Application for Planning Permission for Works or Extension to a Dwelling

Development Rear first floor extension to extend bedroom & provide en-suite facility

Location 140 Barnham Road Barnham

EXISTING FIRST FLOOR PLAN

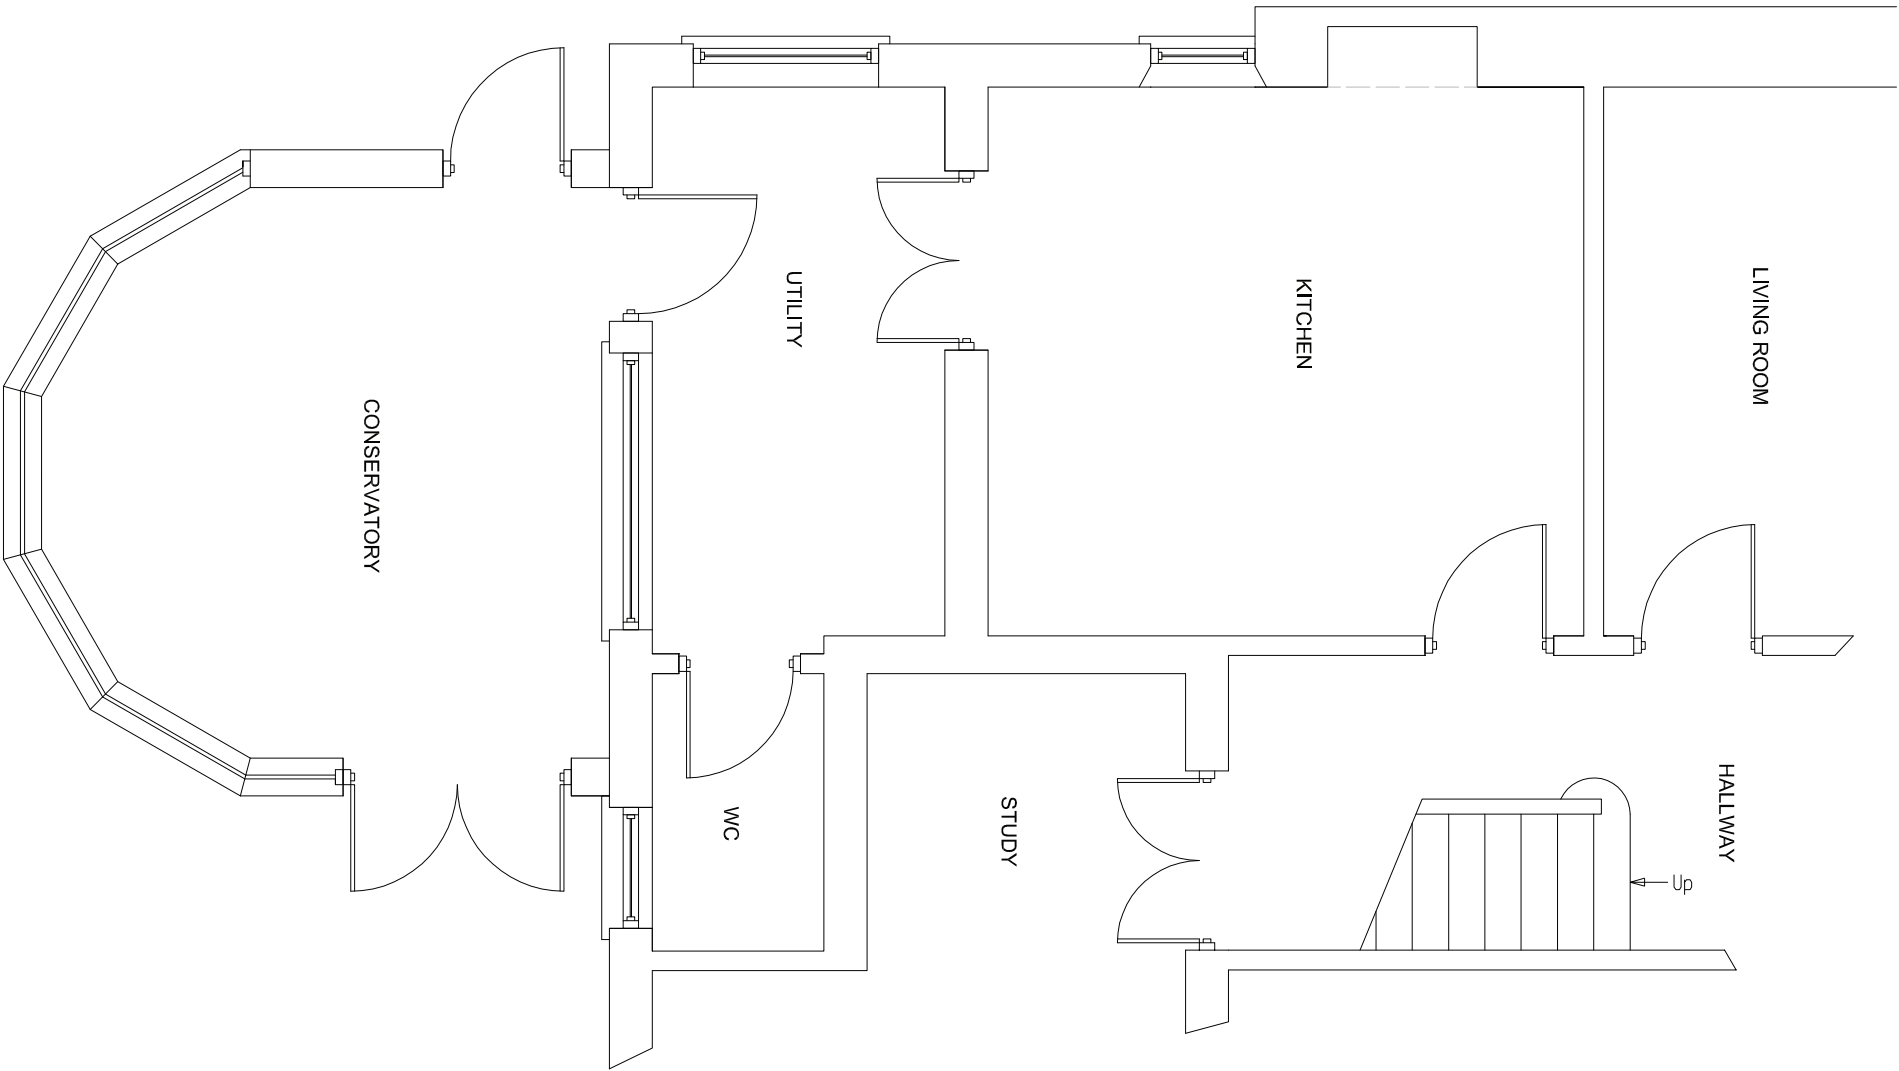
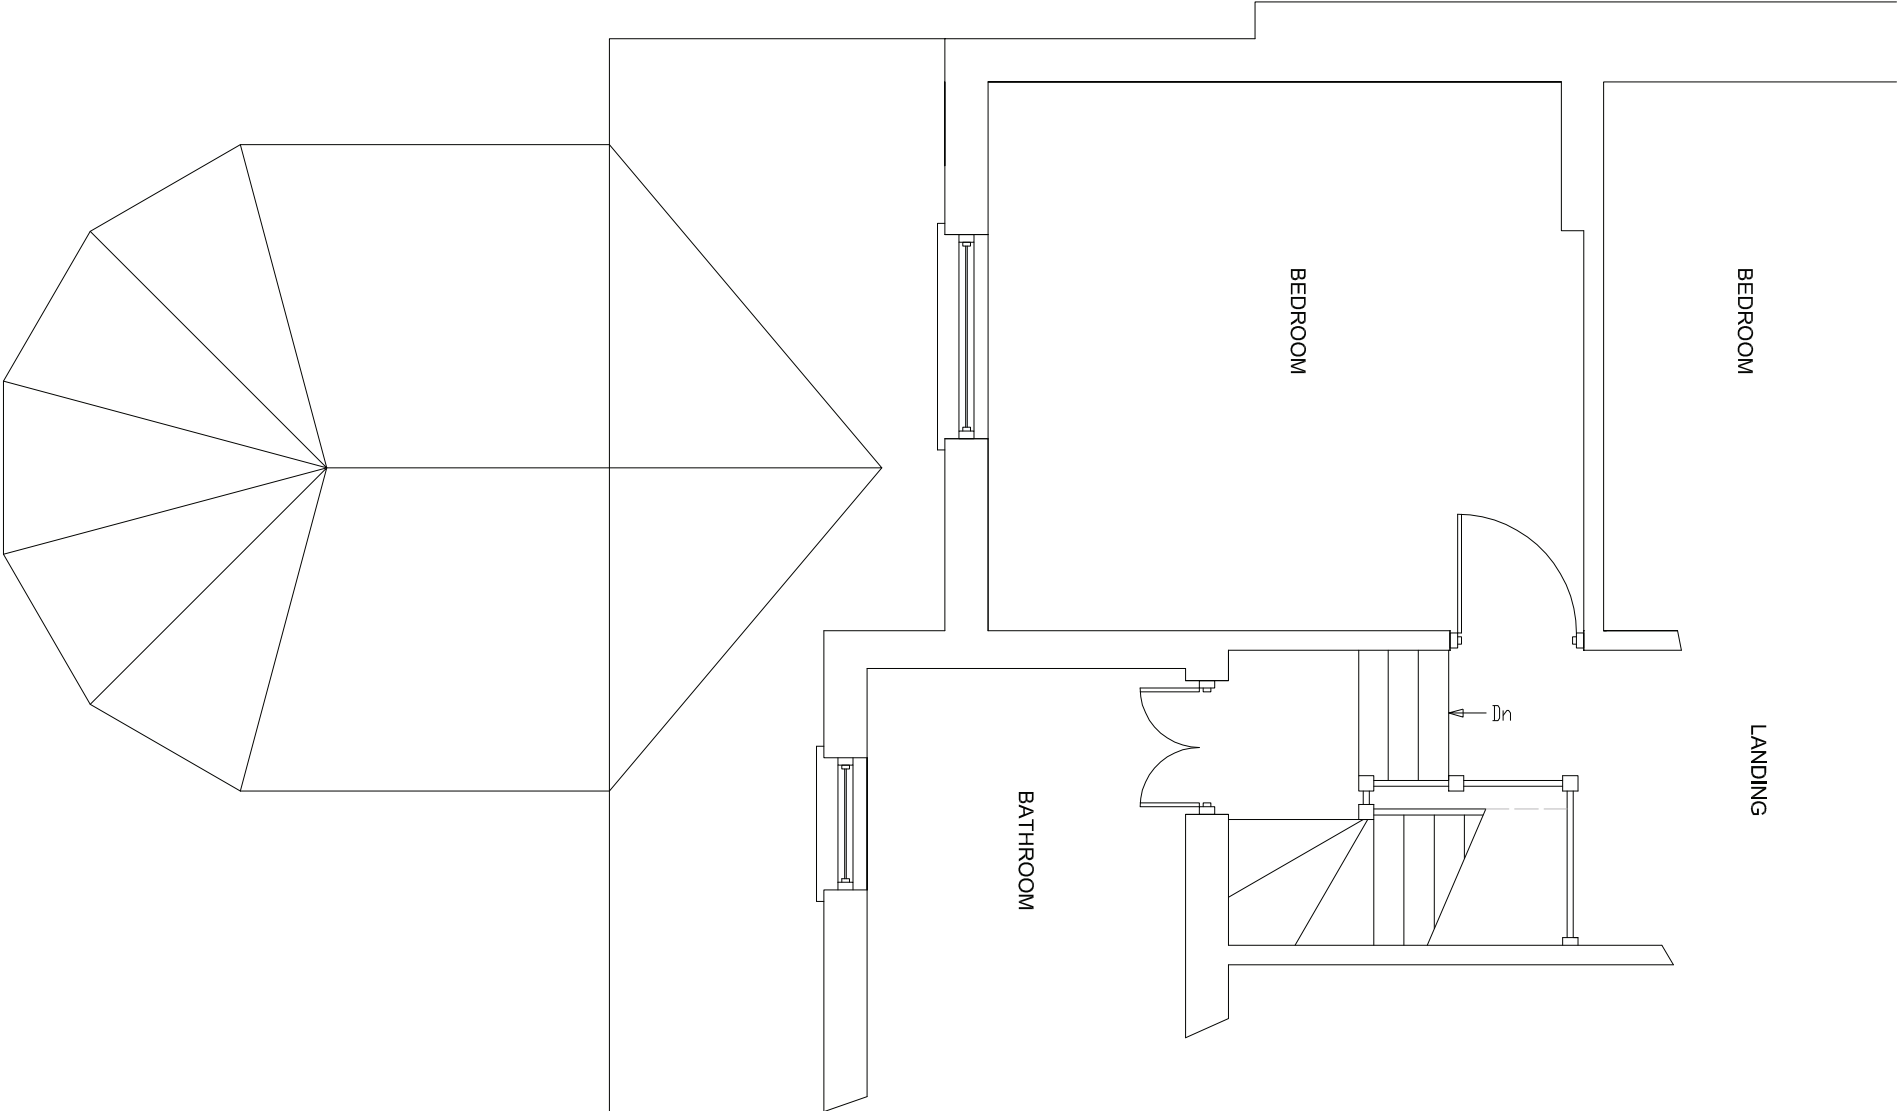
Please provide 1 electronic or 3 paper copies of revised existing and proposed floor plans to show the second first floor window detailed on the existing and proposed rear elevations.
